Item No. **Report of the Head of Planning, Transportation and Regeneration**

Address SILVER BIRCHES TILE KILN LANE HAREFIELD

Development: Part two storey, part single storey side extension, single storey rear extension and conversion of roof space to habitable use to include 2 x front and 6 x rear roof lights involving demolition of existing garage

LBH Ref Nos: **75438/APP/2020/727**

PROPOSED GROUND FLOOR PLAN - 1:100

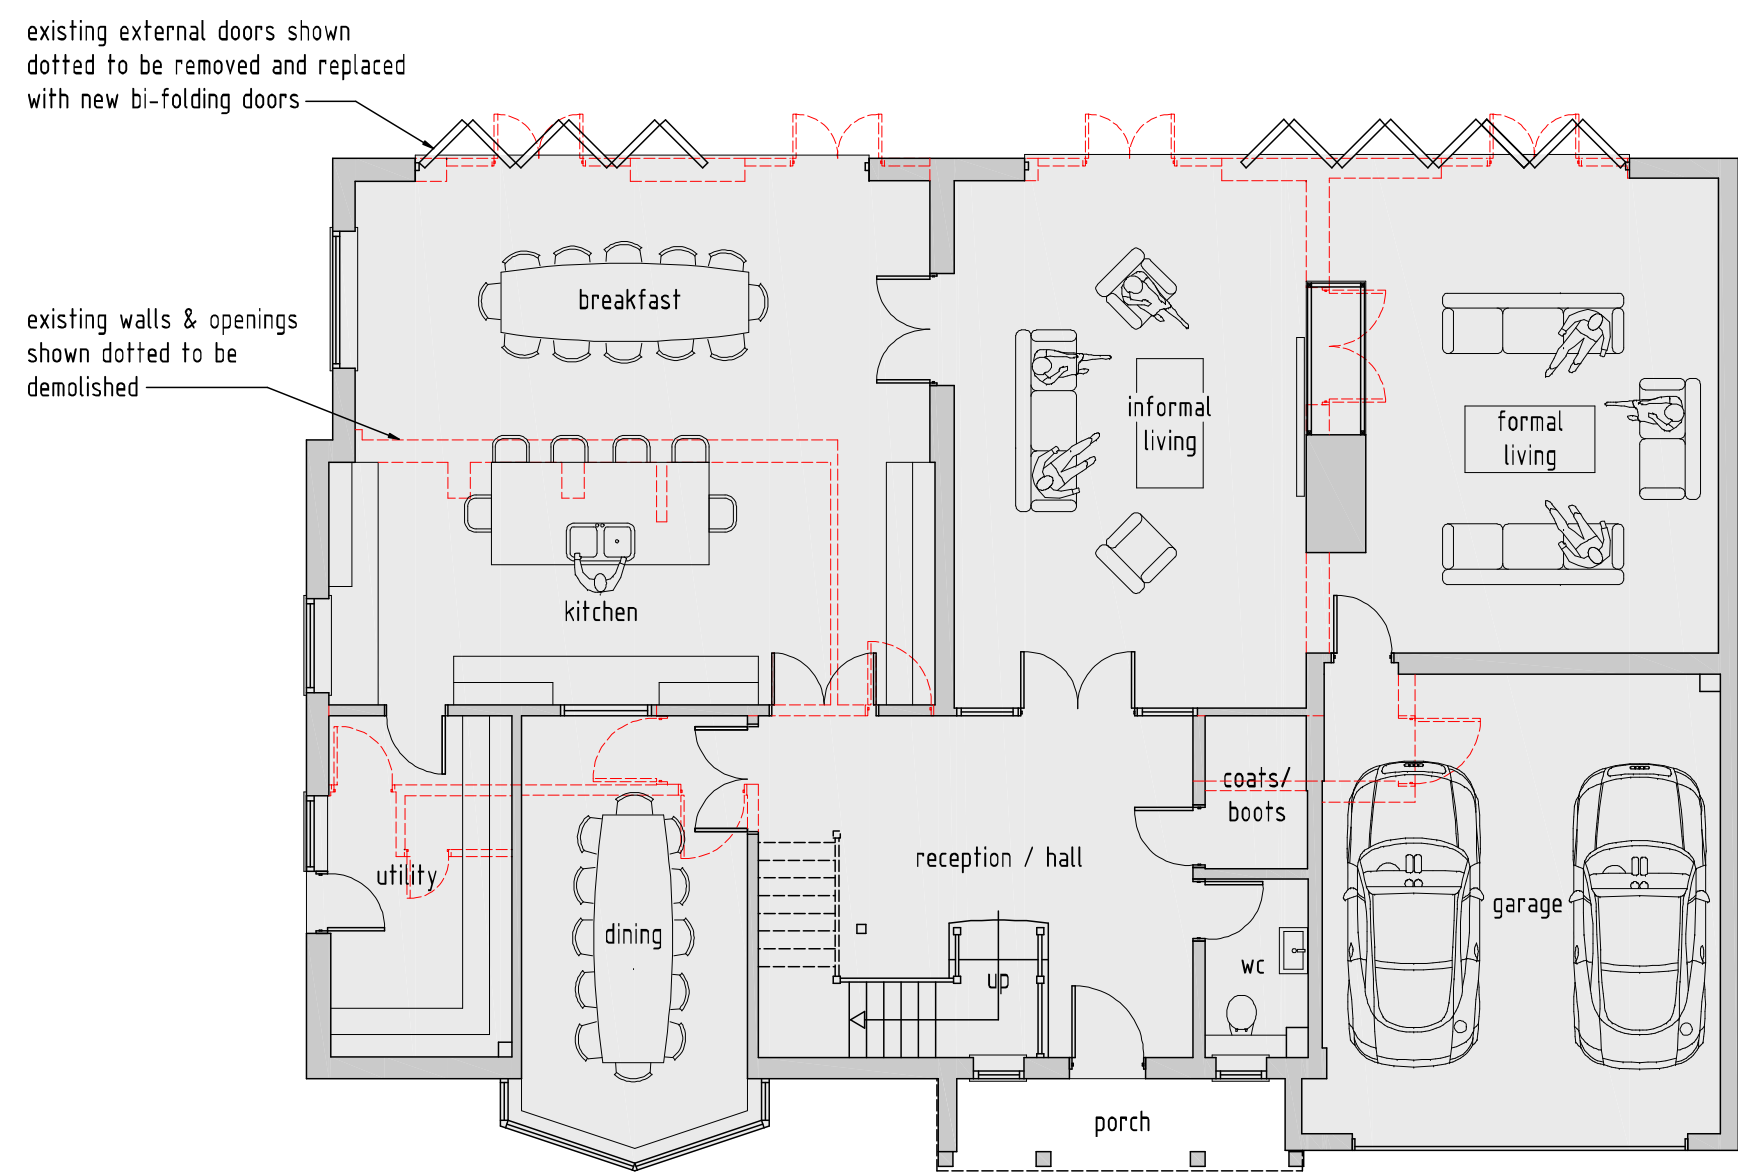
Whilst it is noted that the side extensions sit largely on the footprint of the existing linked garage, this is a substantial addition to the original property. The proposed side extension measures 10.4m in width in comparison to the 11m width of the original dwelling, increasing the height and extending forward of the main front building line. The floor area of the original dwelling and garage was approximately 230sqm. The proposed extension would result in a dwelling with a floor area of approximately 481sqm, over double the size (an increase of 109%). The proposal would therefore fail to appear subordinate to the existing property and would be a disproportionate addition over and above the size of the original building. As such, the development fails to comply with the requirements of Policies BE1 and EM2 of the Hillingdon Local Plan: Part One - Strategic Policies (November 2012), Policies DME1 4, DMHB 11 and DMHD 1 of the Hillingdon Local Plan: Part Two - Development Management Policies (2020), Policy 7.16 of the London Plan (2016) and the NPPF..

The proposed two storey side/front extension and single storey side extension, by virtue of its size, scale, bulk and width, including the lack of set back from the front elevation, would fail to appear as subordinate additions and would thus, fail to harmonise with the architectural composition of the original dwelling. As such they would be detrimental to the character, appearance and visual amenities of the street scene and the surrounding area. Therefore the proposal would be contrary to Policy BE1 of the Hillingdon Local Plan: Part One - Strategic Policies (November 2012) and Policies DMHB 11 and DMHD 1 of the Hillingdon Local Plan: Part Two - Development Management Policies.

PROPOSED REAR ELEVATION - 1:100

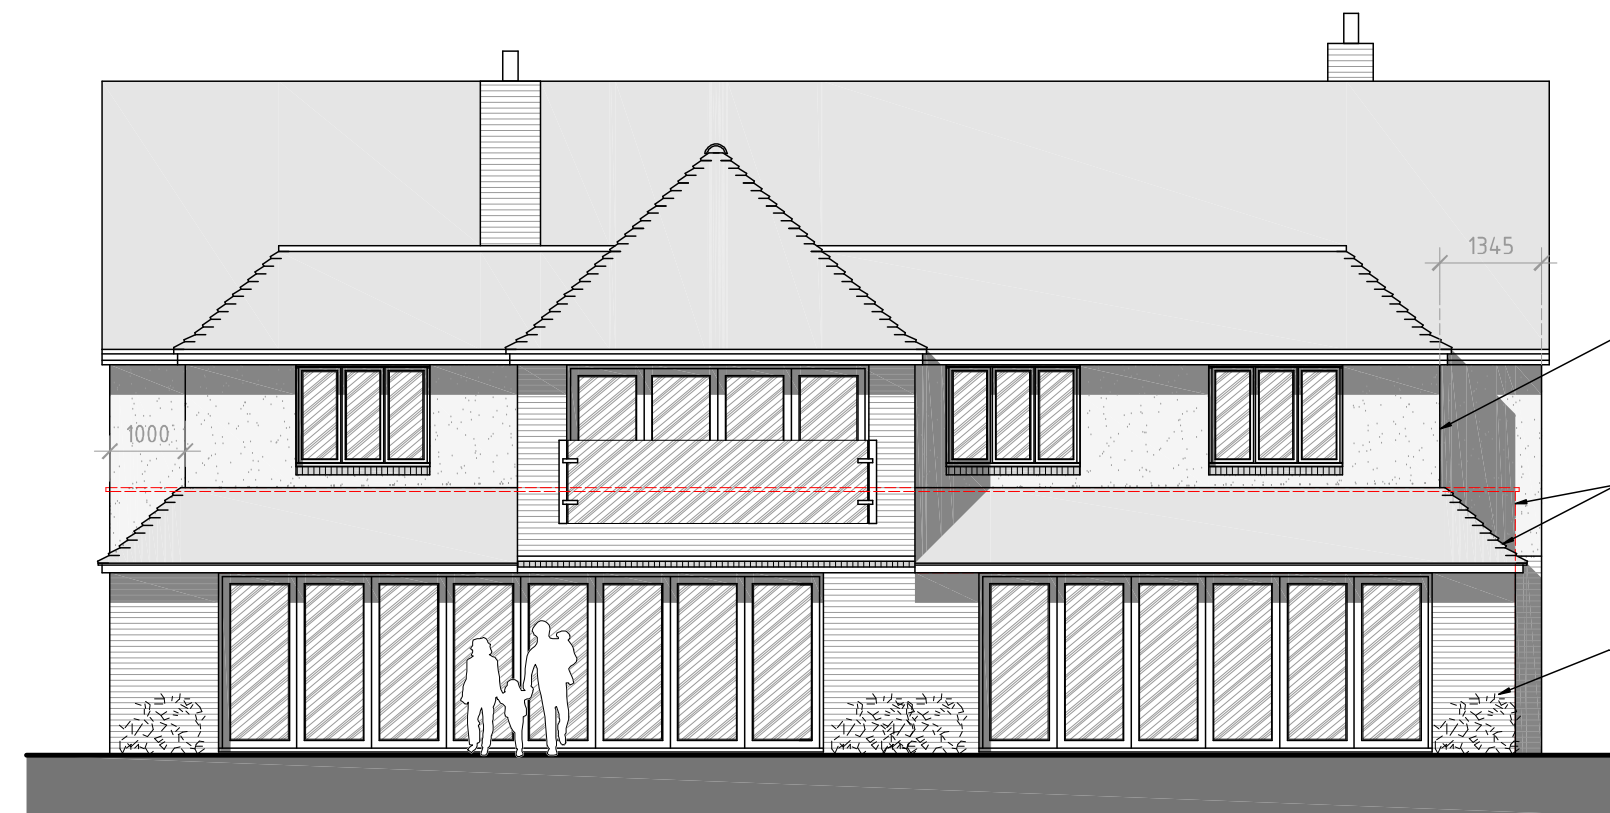
parapet. The rear extension then returns across the whole of rear elevation (including the proposed two storey side extension) at a depth 4m.

The proposed extension by reason of its size, scale, bulk, height and width, would represent a disproportionate change in the bulk and character of the original building and therefore would significantly increase the built up appearance of the site and would be visually intrusive within the street scene and the wider area. The proposal would therefore constitute inappropriate development in the Green Belt, contrary to Policies
